Dear Sir/Madam,
RE: Lots 18, 20 36, 37, 38,39, 40 & 41 of SP 74416 - 85 George Street,
Parramatta - Proposed Development of 89 George
Street, Parramatta.

**RE: Objection to Proposed development
No 89 George Street Parramatta
Your Reference: MP 09_0128 - Commercial Retail Development**

Planning Direction has been engaged by *Strata Plus Pty Ltd* (Managing Agents for the owners of property No 85 George Street Parramatta.) to review the above development application and to provide advice in respect of the town planning aspects of the proposed development.

55m ABOVE NATURAL GROUND

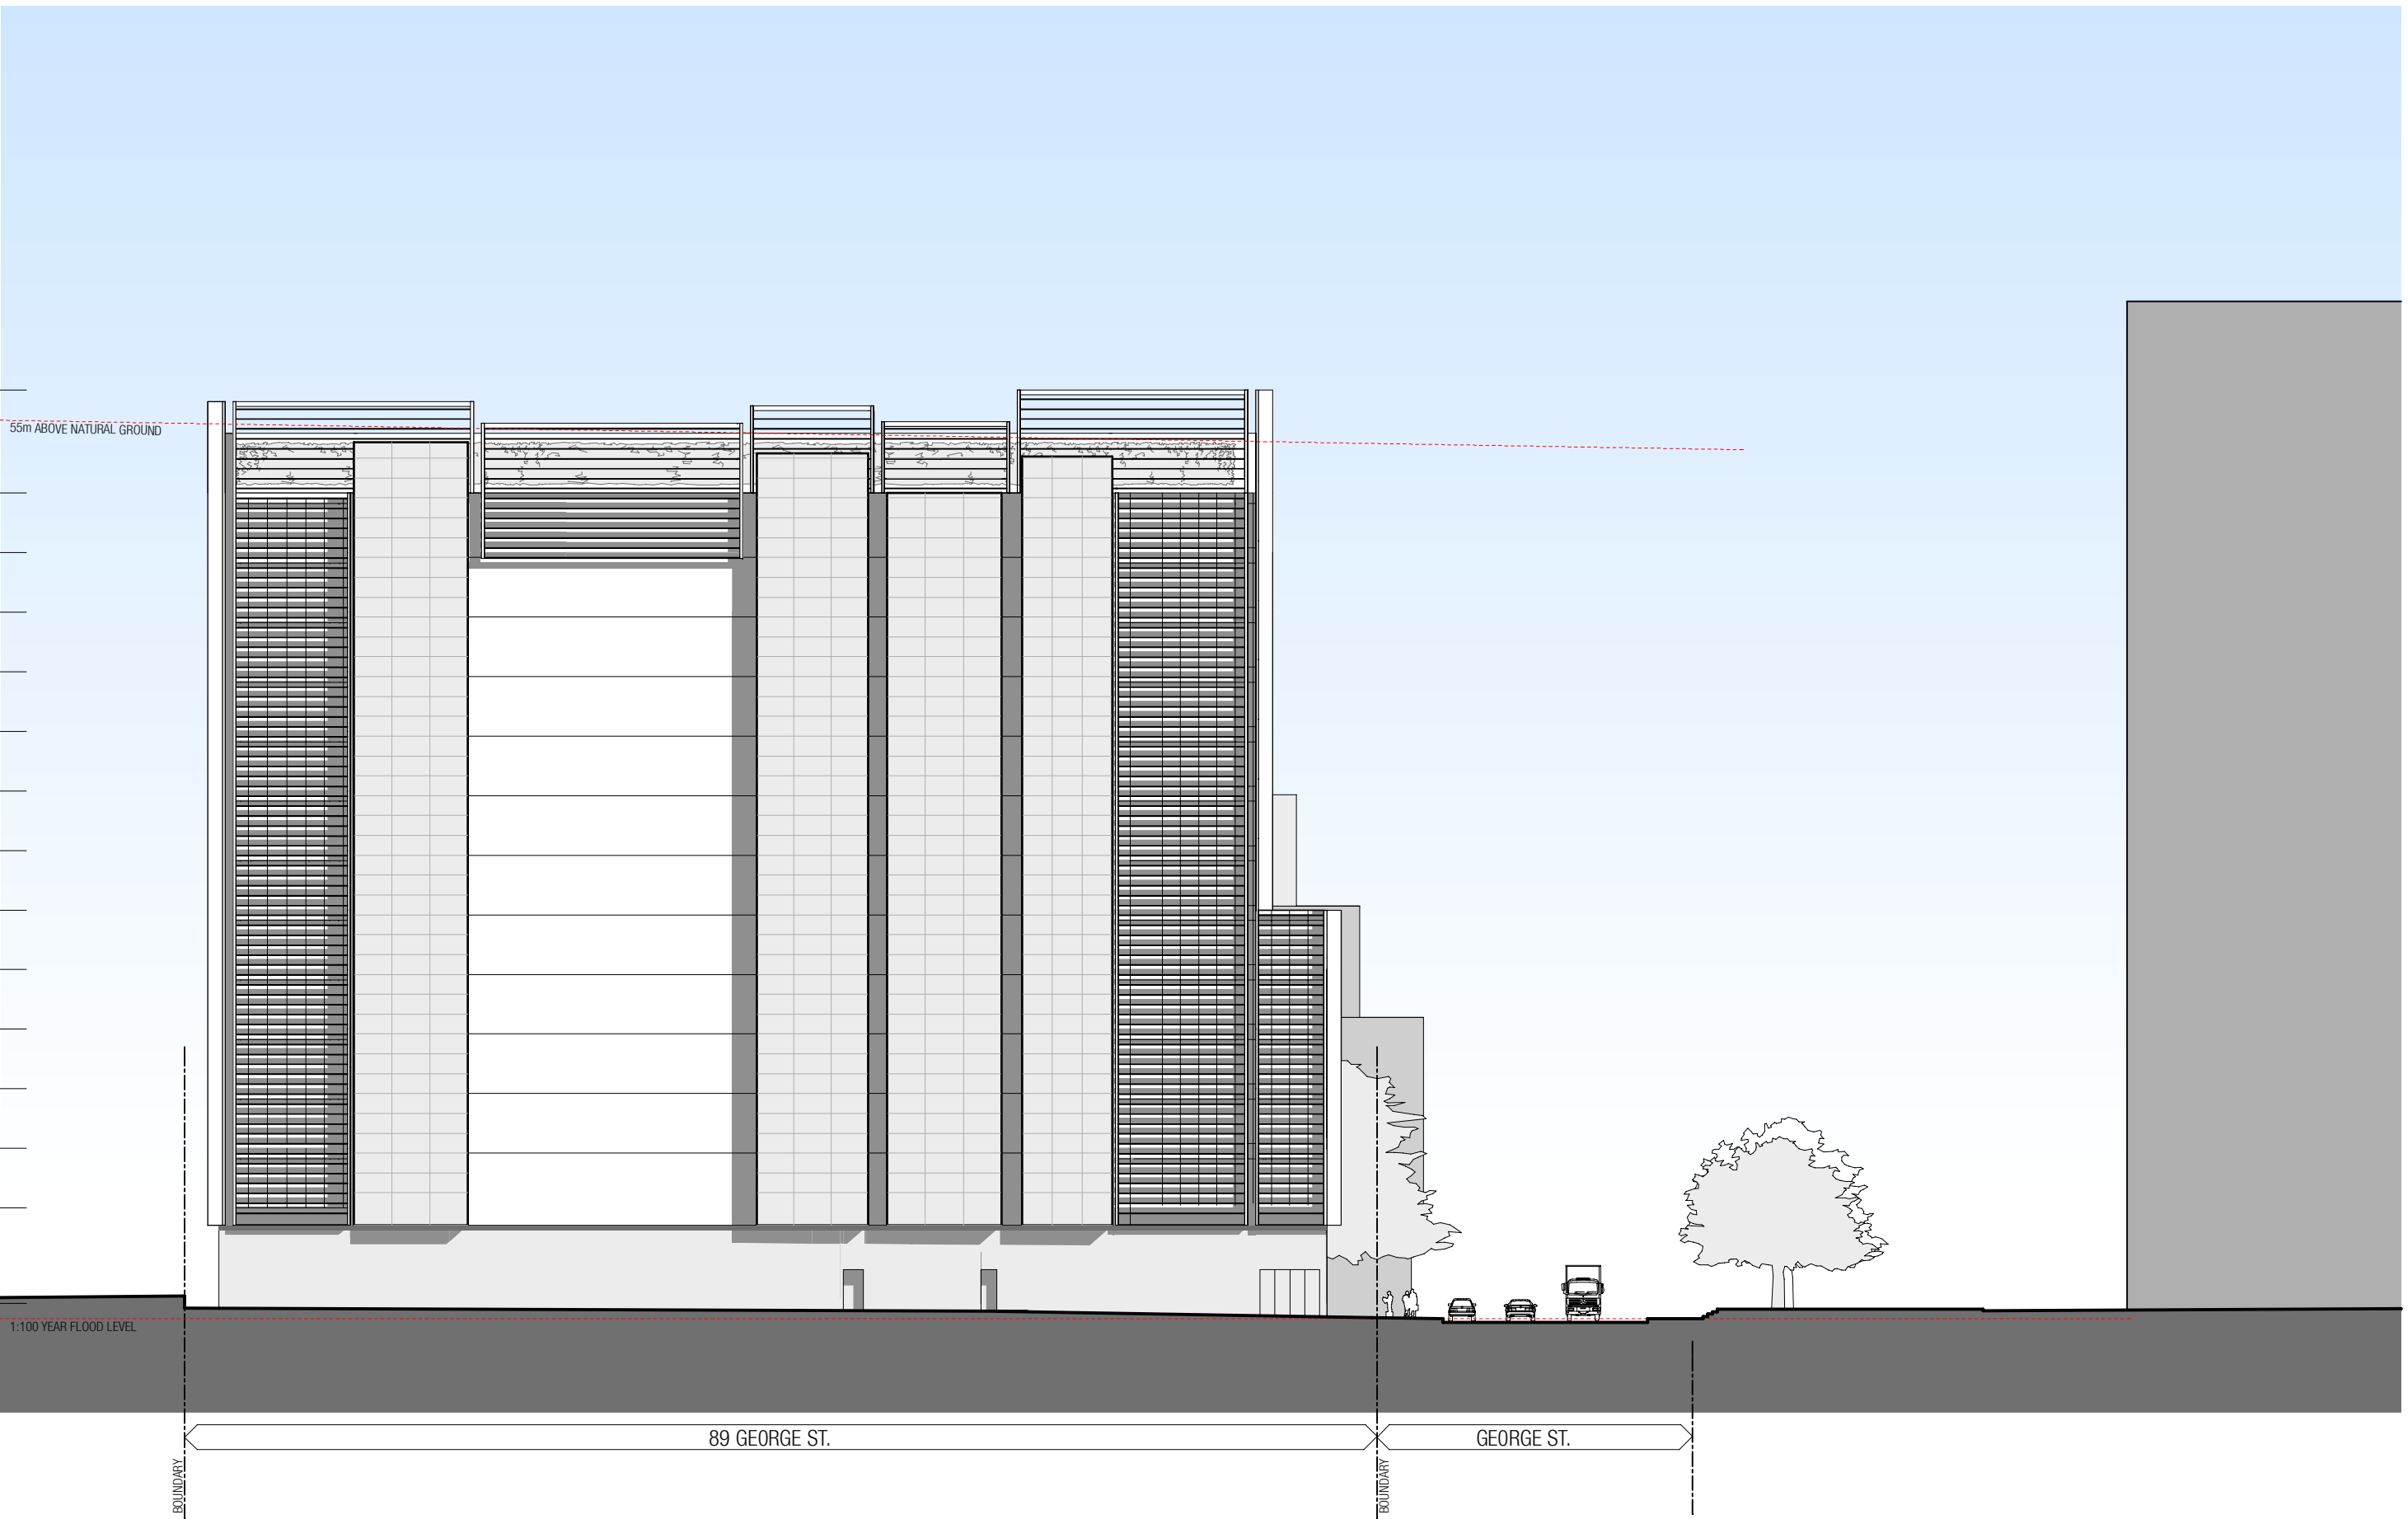
Rather than respond to the established development pattern, the design proposal presents a continuous high rise building wall immediately adjacent to Perth House rising in height to a thirteen storeys (or 55m) and with a wall length of some 75m. The constrained width of the site and non compliance with building setback and building separation controls reduce the opportunity for effective building articulation.

The development will not enhance and protect the existing landscaped setting and well established curtilage of Perth House, it will ‘stand over’ and ‘overwhelm’ Perth House and its grounds severely compromising its heritage significance and streetscape value.

In this respect the proponents expert reports have advised that the proposed variation to the maximum FSR control manifests in an additional 3 storeys commenting “*Strict enforcement of the FSR standard would result in the loss of 3 levels of floor space*”. The additional three floors significantly increase the building bulk and mass. The additional floor space is squeezed into a very constrained development site and this manifests in unacceptable adverse impacts.
